From: Juan Baeza
Sent: 13 June 2018 10:53
To: Planning.Responses
Cc: Timothy Bloomfield
Subject: FW: A/23/18/DOC - Broadlees, Dappers Lane, Angmering

With regard to condition 19 the following comments have been received from the Council's Consultant Arboriculturist:

TREE PROTECTION (Plan 3A)

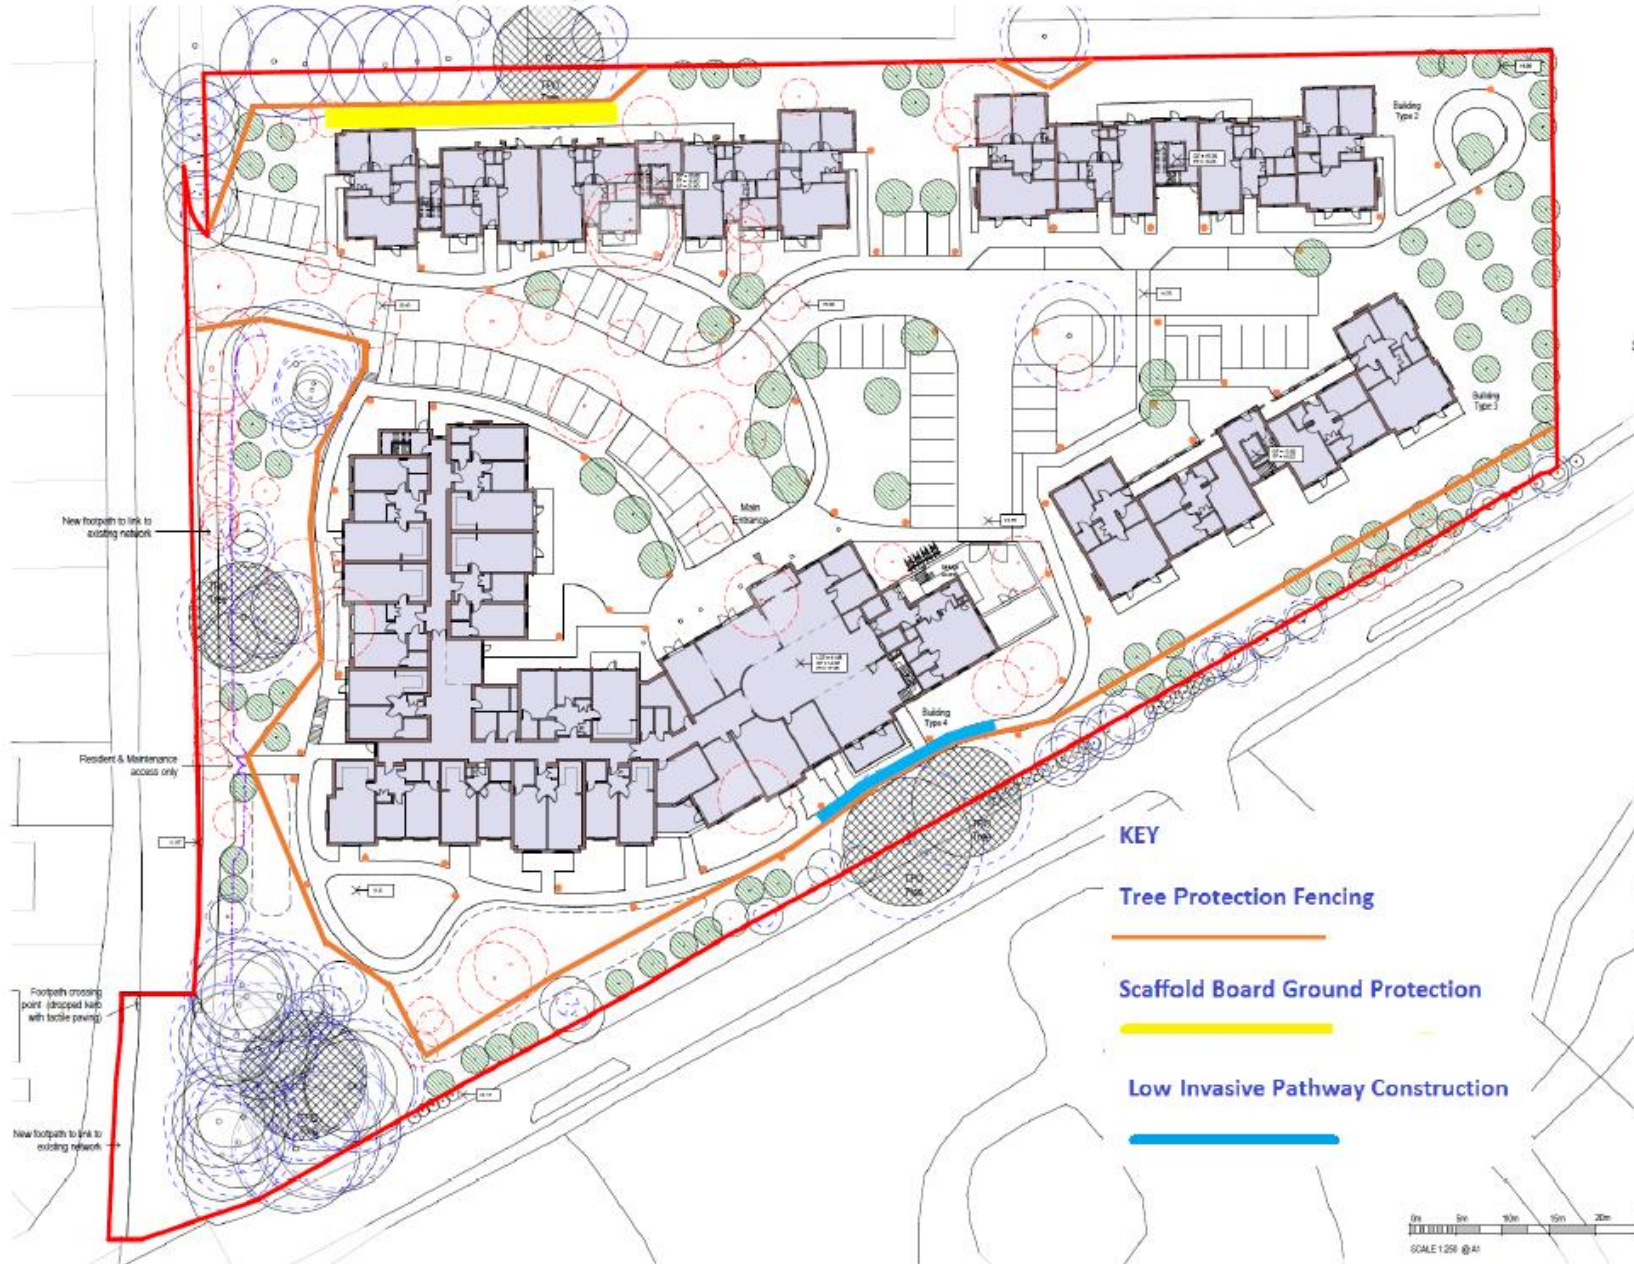
In the absence of general vegetation clearance and erection of Protective Fencing the Condition has not been complied with and I am therefore unable to sign it off at this time.

I note that the applicant has submitted a Tree Protection Plan Ref: Plan 3A – the measures set out on this plan are acceptable but will need to be implemented and then a Pre-Commencement Meeting can take place [at a mutually convenient time] between the applicants representative and the Arun DC Tree Officer to agree that the Protective Fencing complies with BS5837 recommendations and is 'Fit For Purpose' and that it has been erected exactly as shown on Plan 3A”.
